The Wildlife Trusts

The Wildlife Trust reference: 20022896.

6 December 2019

Written Representation by The Wildlife Trusts for Norfolk Vanguard Offshore Wind Farm

Title:  
Harbour porpoise PTS ranges based on worst-case scenarios

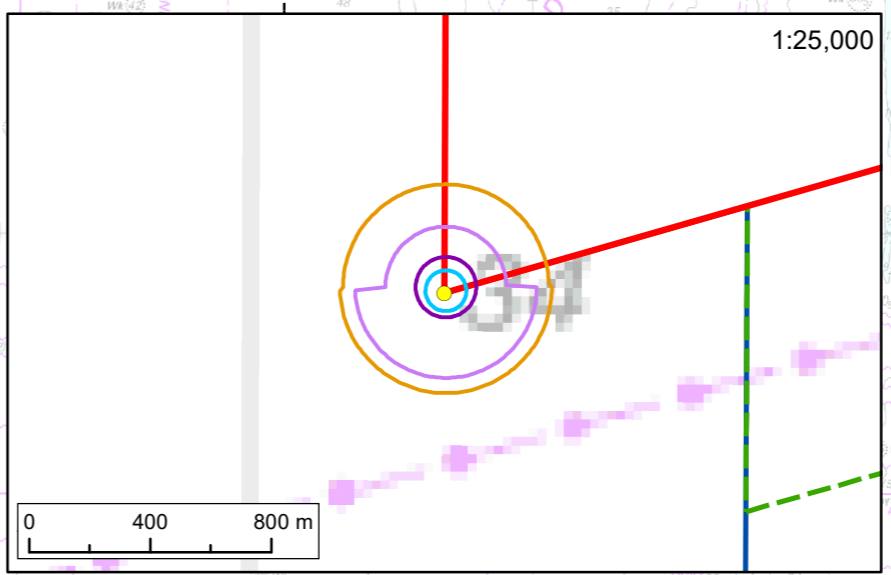
2.2. The impact assessment for Norfolk Boreas has shown a major adverse effect for PTS in harbour porpoise from UXO clearance (ES, Table 12.24). This assessment is supported by peer-reviewed evidence³. In addition, table 8.11 in the Information to Support the Habitats Regulations Assessment shows that PTS impacts could be up to 14.4km and currently there is little evidence to support the effectiveness of mitigation at this distance. Therefore, the developer will need to provide proven mitigation during the implementation of this activity to ensure no adverse effects from injury impacts.

2.3. As no draft MMMP for UXO clearance has been produced as part of the dDCO, we cannot agree with certainty that there would be no adverse effect from PTS impacts from this activity.
